INDEPENDENT EXPERT REVIEW

WHITE ROCK WIND FARM PROPOSAL

*Prepared for
NSW DEPARTMENT OF PLANNING
& ENVIRONMENT*

17th July 2019
REF: 990-Z1-01
REVISION: D

View angle toward WRWF Project Approval and Stage 2 wind turbine tip of blade from a 2 km view distance

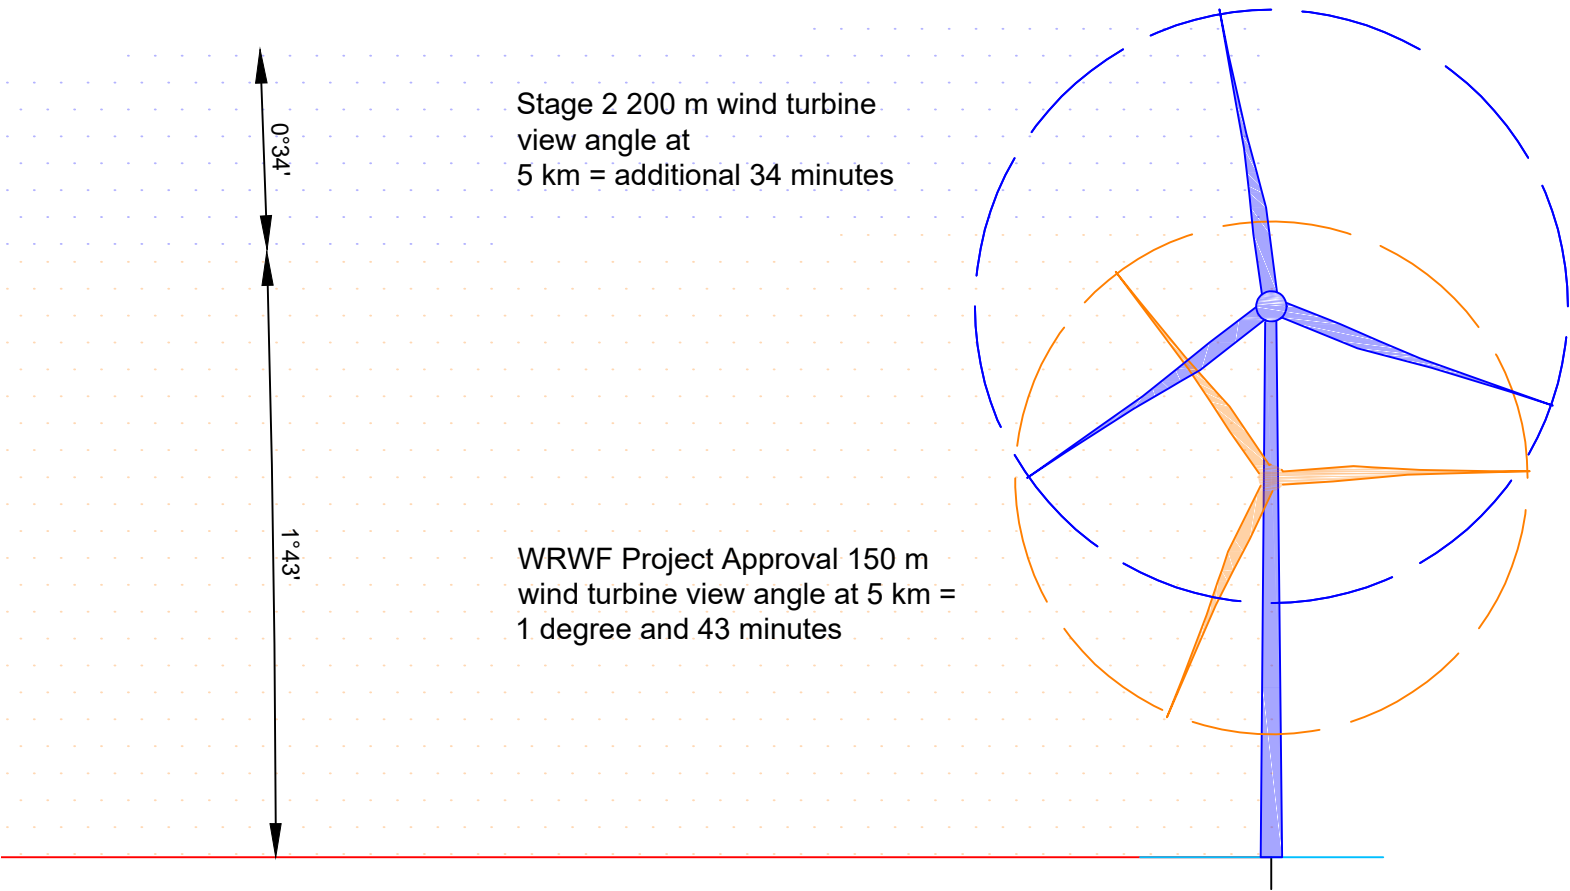
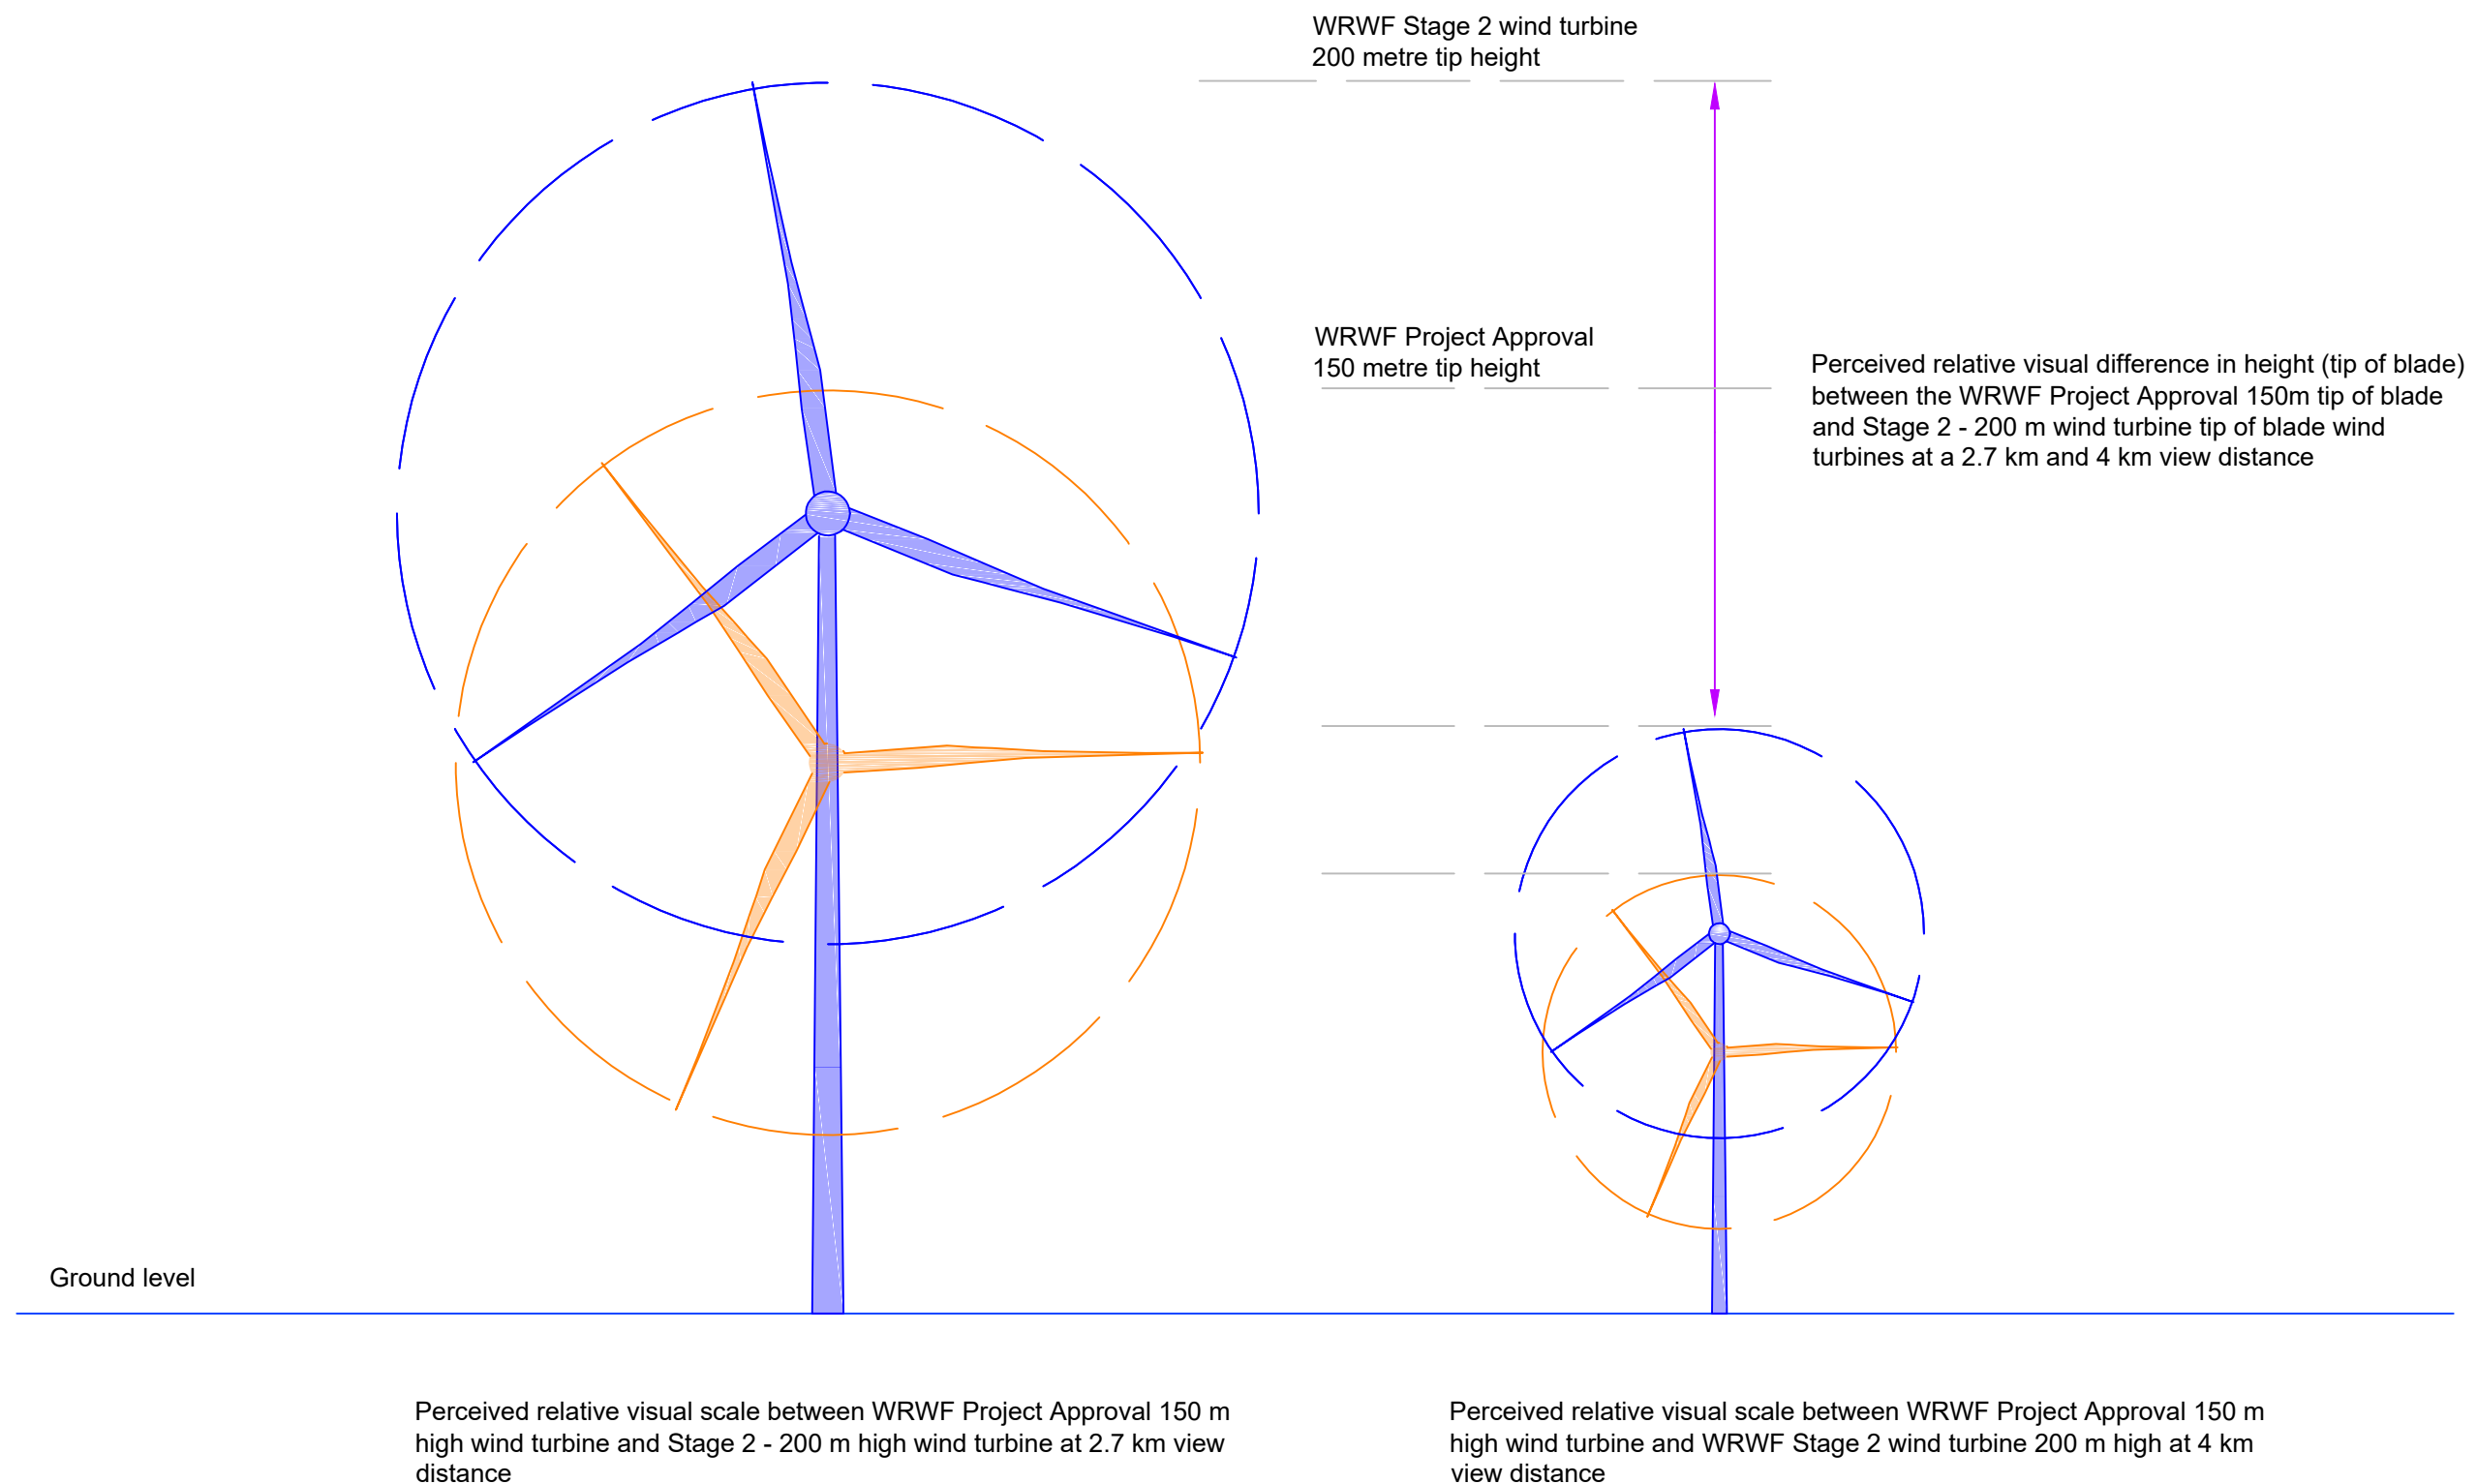
In section 4 of the LVIA a list of the numerical differences between the the 2012 Approval and Mod 6 turbine layout and characteristics is provided. A conclusion is then reached in section 4.4 that "*views toward additional wind turbine rotors and blade tips are not considered to result in a magnitude of visual effect which is greater than the magnitude of the visual effect associated with the WRWF Project Approval.*" This conclusion does not appear to have any analytical basis related to each individual residence or impact other than an intuitive balancing by the assessor of the numerical changes.

In our opinion, this methodology results in several steps of the visual assessment process outlined in the VAB not being properly considered. This includes use the multiple wind turbine tool, the preparation of a visual baseline study, identification of a scenic quality class and most critically; a performance evaluation based on the objectives for each zone/viewer level set out in the VAB.
